West Midlands Interchange

Application Statement for Proposed Non-Material Change

West Midlands Rail Freight Interchange Order 2020 (as amended)

June 2023

B4 - Proposed Road Bridge, Over Existing Canal (Elevation E4)
(Scale 1:100)

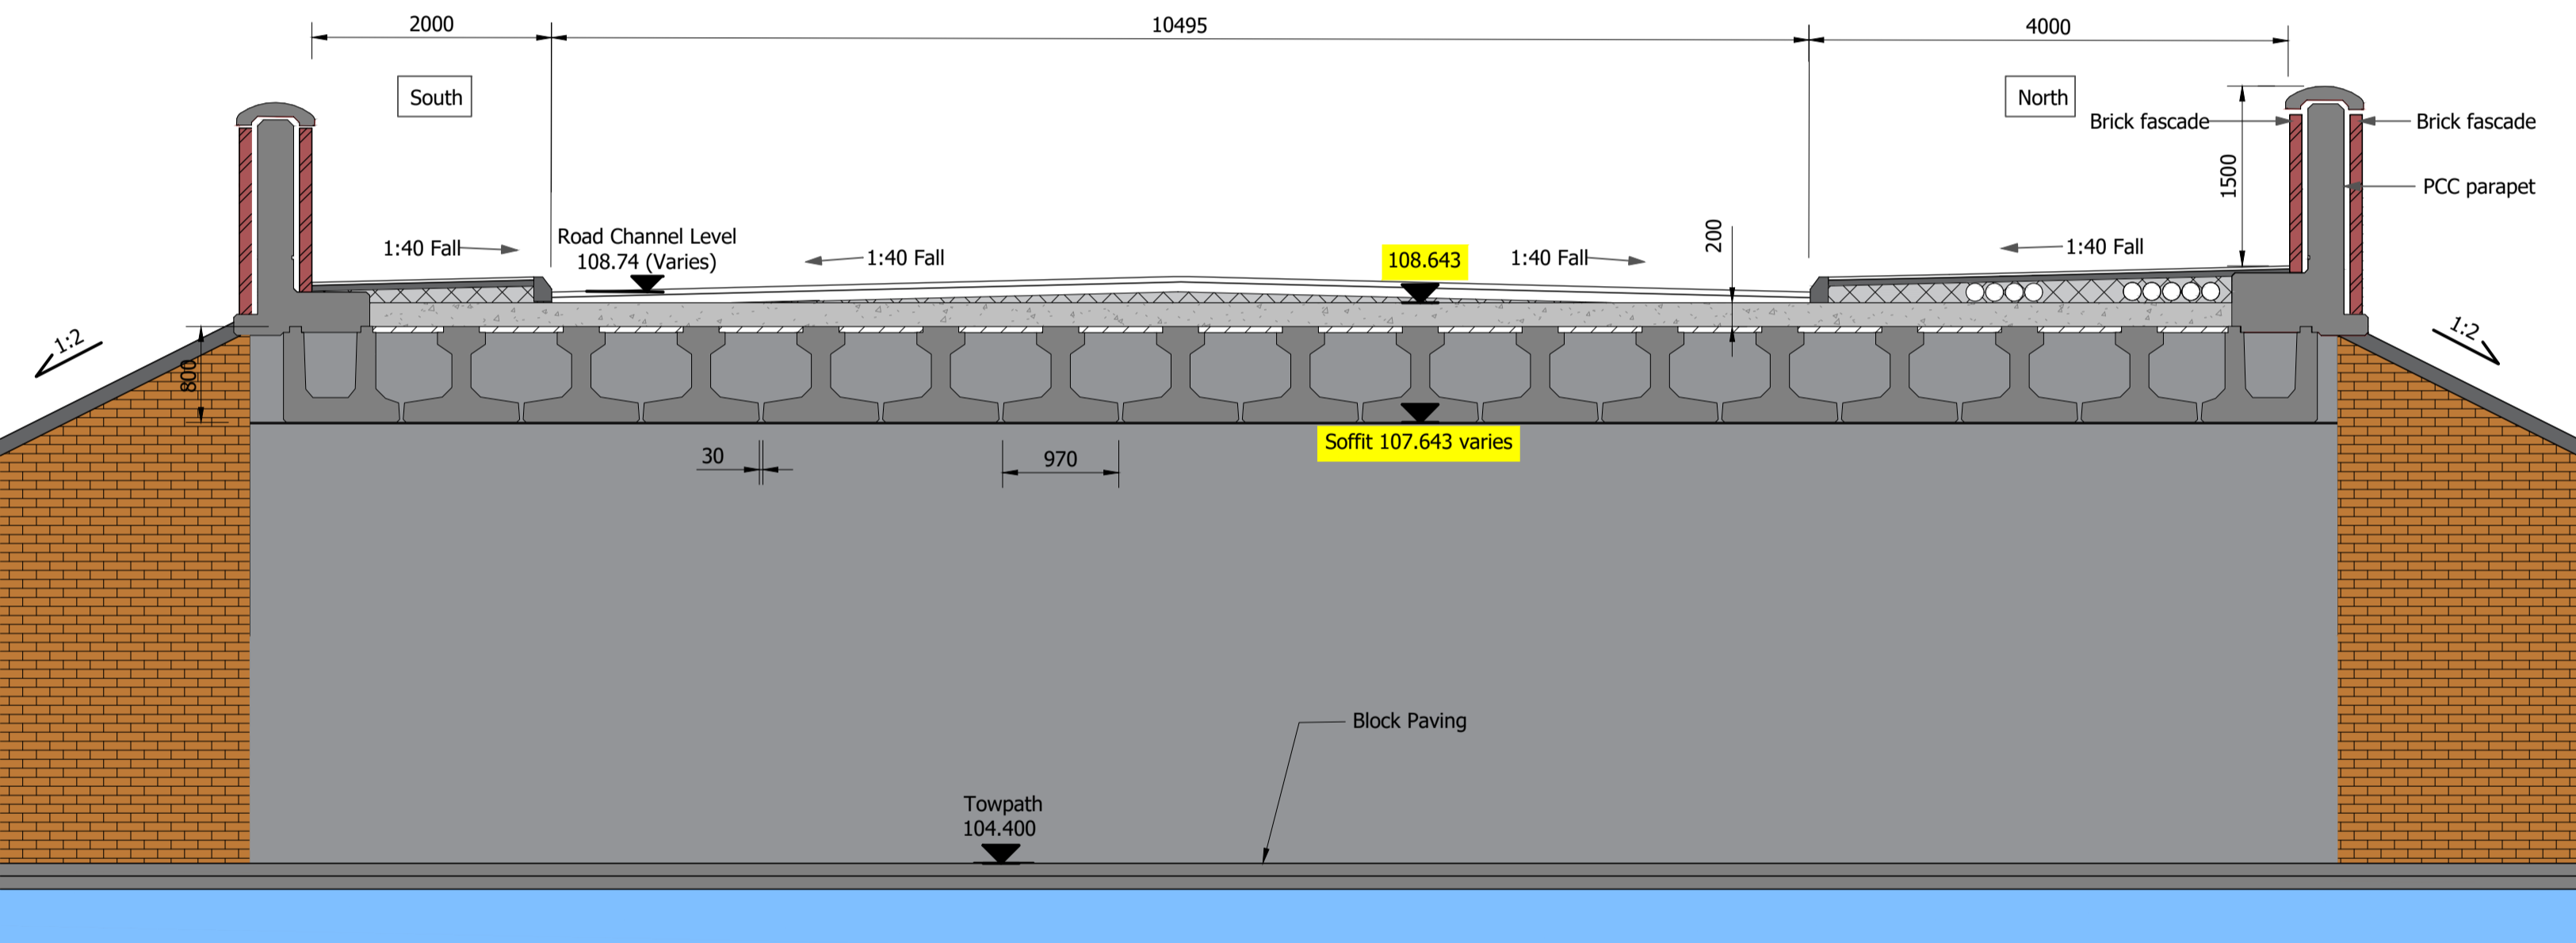
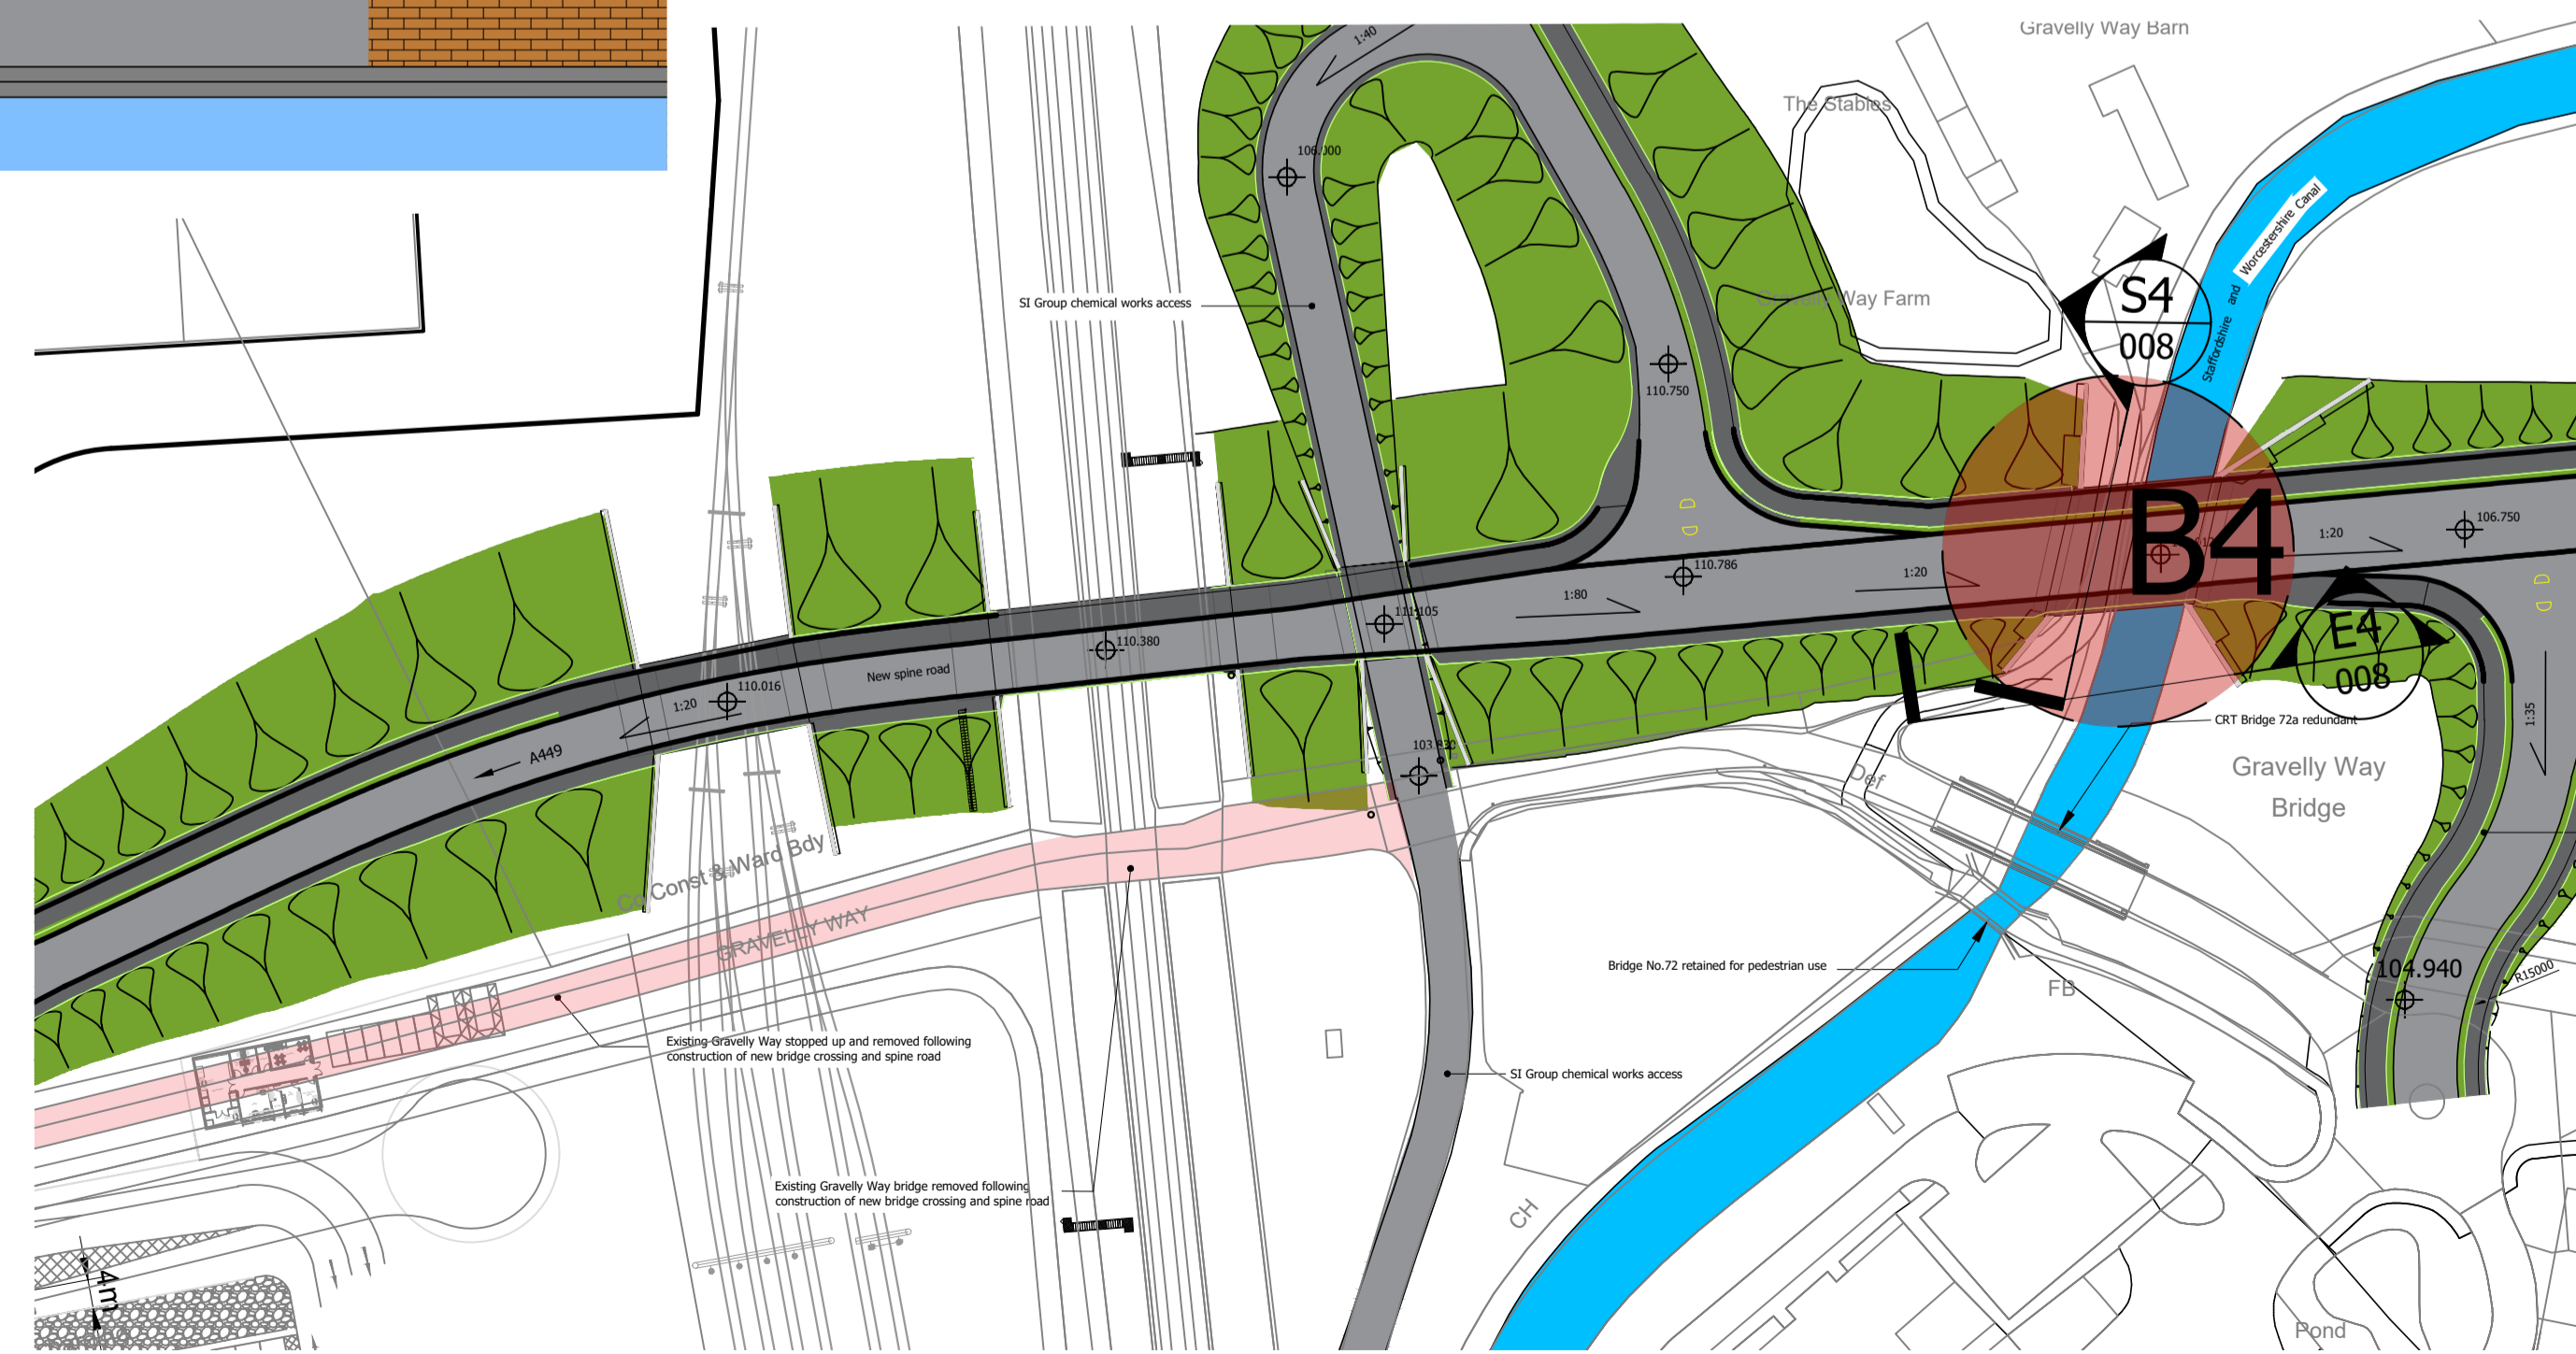
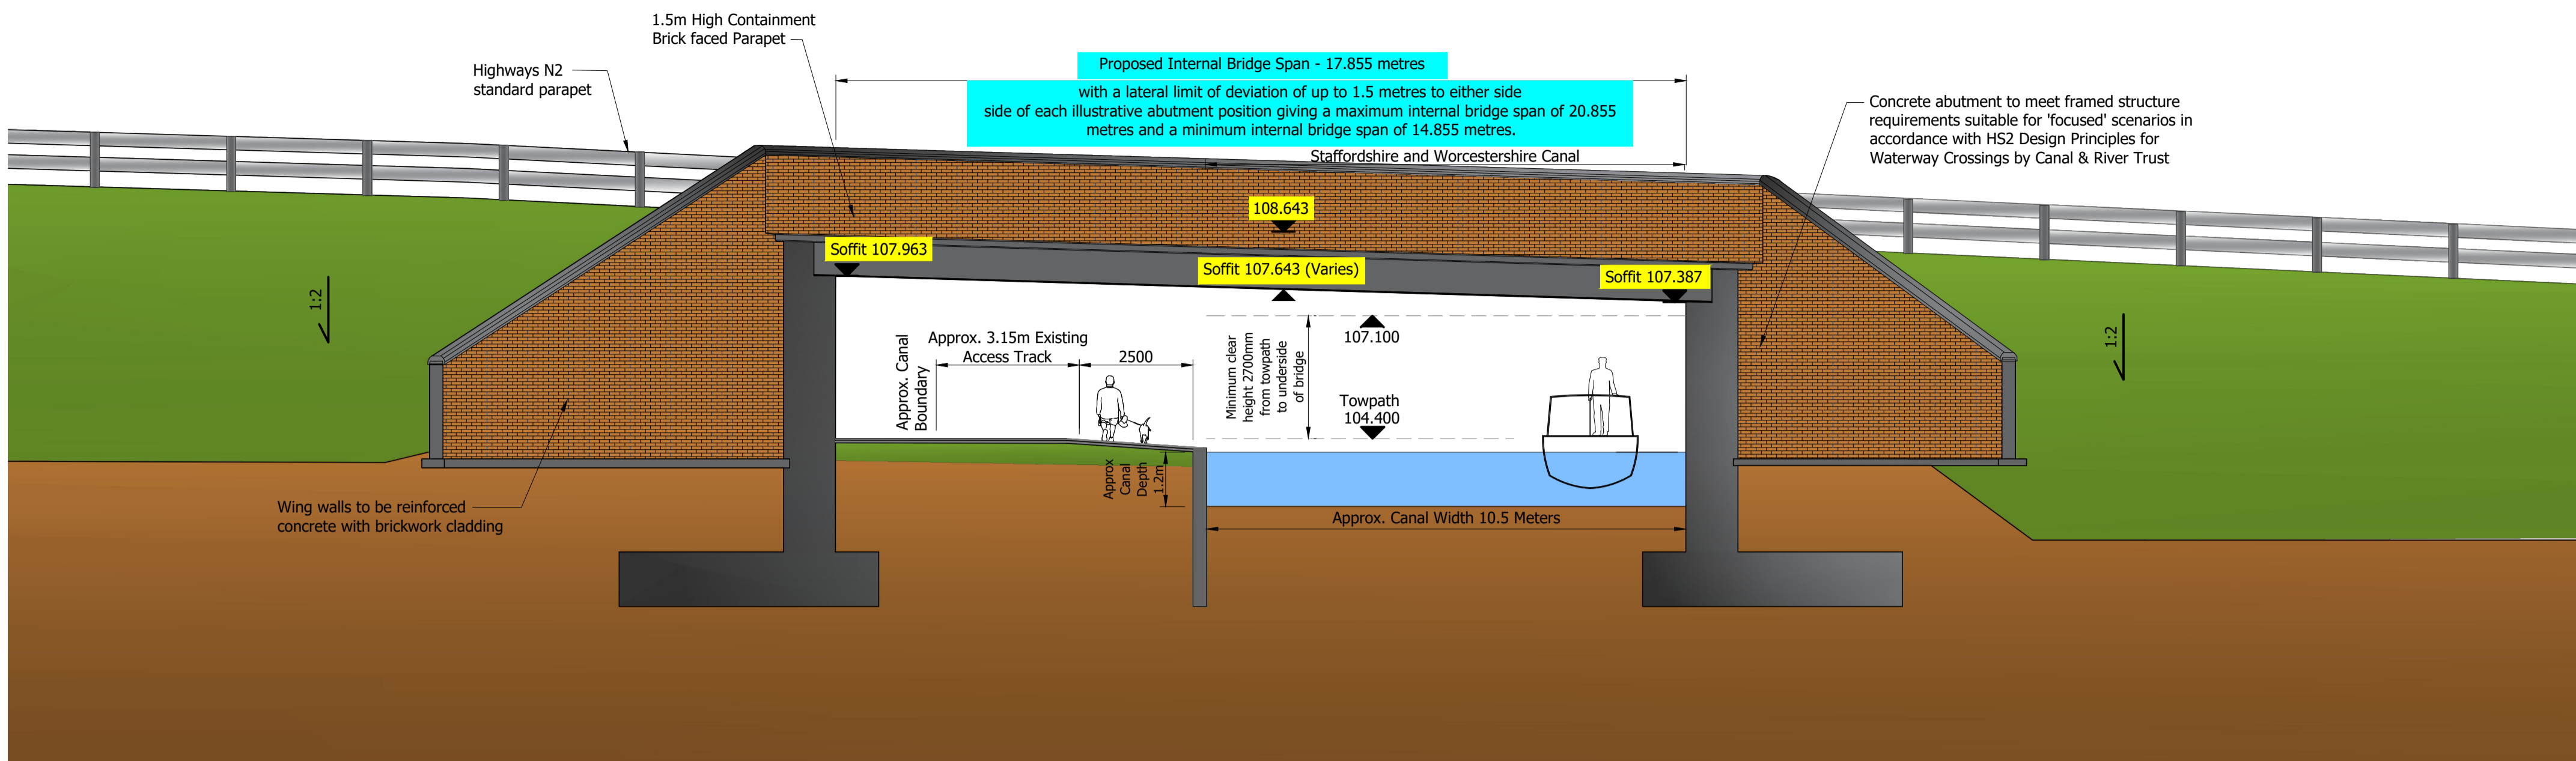
- **Bridge No.4** – reducing from approximately 20 metres to 17.855 metres.
13. In order to provide sufficient flexibility to accommodate any further detailed design development, it is proposed that the bridge plans allow for the following horizontal limits of deviation to abutment positions and associated internal bridge spans (as annotated on the proposed bridge plans):

- **Bridge No.4** - allowing 1.5 metres lateral deviation on either side of the illustrative abutment positions so that the maximum and minimum internal bridge spans permissible under the amendment are 20.855 metres and 14.855 metres respectively.

- **Bridge No. 4** – reducing the proposed carriageway height by an average of circa 0.4 metres (from an average of 109.000m AOD to 108.643m AOD) and increasing the proposed soffit height by an average of circa 0.4 metres (from an average of 107.270m AOD to 107.643m AOD).

32. The 2.1 metre reduction in span, together with the defined limits of lateral deviation to the bridge abutment locations and internal span width, is proposed further to discussions with Canal and River Trust ('CRT') to provide for an option where the east bridge abutment in that area could be moved closer to the Staffordshire and Worcestershire Canal, subject to agreement with the CRT. The changes provide flexibility to potentially reduce or remove space between the eastern boundary of the canal and the eastern abutment, which is currently consented, thereby removing an opportunity for and to deter anti-social behaviour and graffiti in this area.
33. The width of Bridge No.4 does not require alteration because the current width is sufficient.
